Lr.No: A2/9563/92

Sub: MMDA - Planning Permission - Construction of  
residential building in Plot No: 111 at  
S.No: 159/2 of Sathangadu  
village - Approved - Reg.

SITE PLAN SCALE 1" = 16'-0"

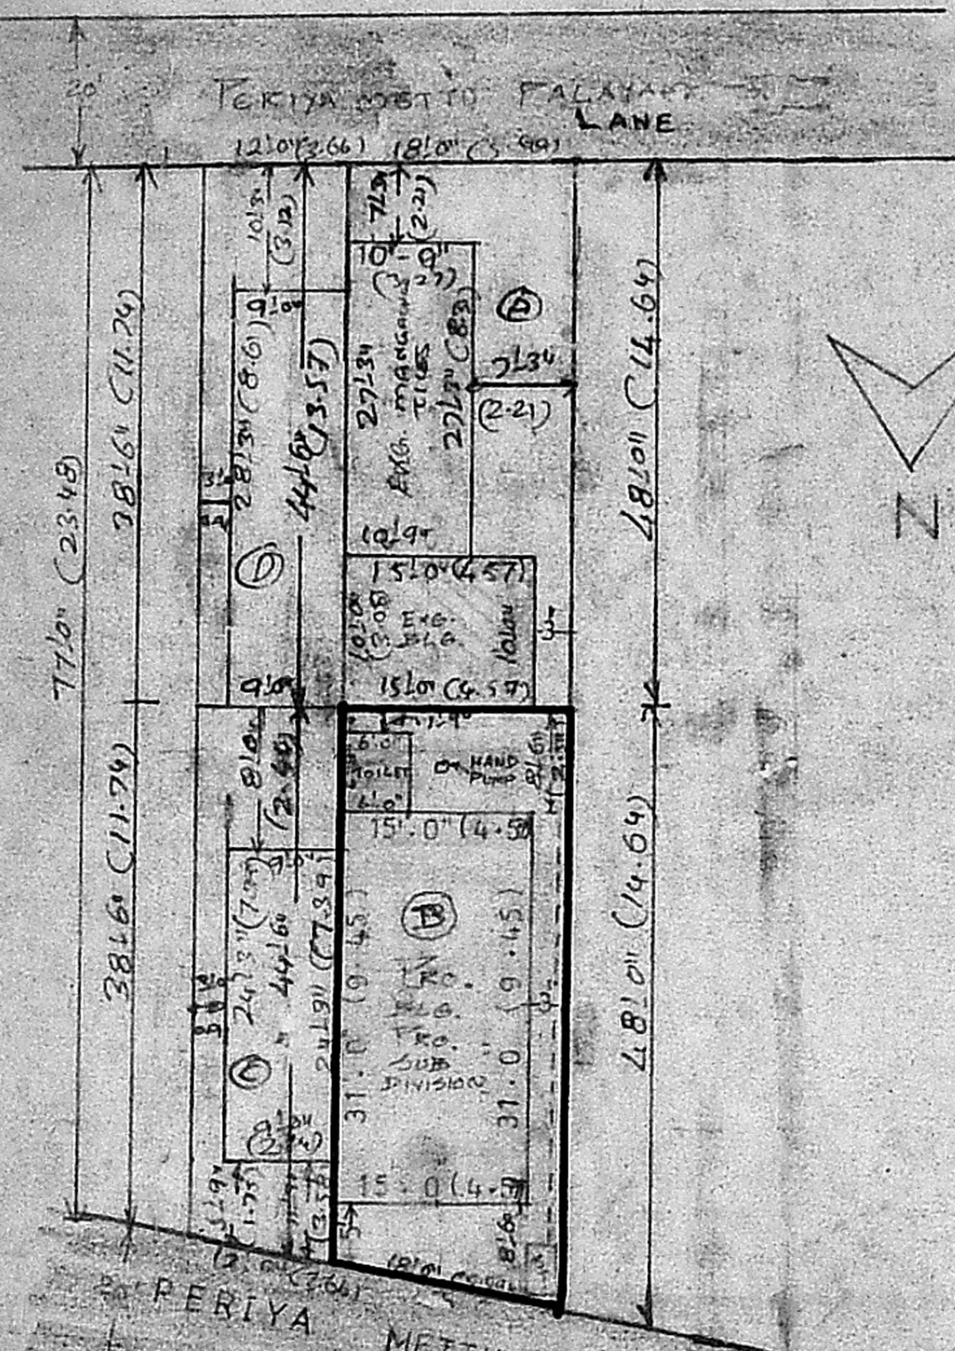
\* You are also requested to furnish 5 sets of revised  
plan incorporating the site boundary measurements  
as per document.
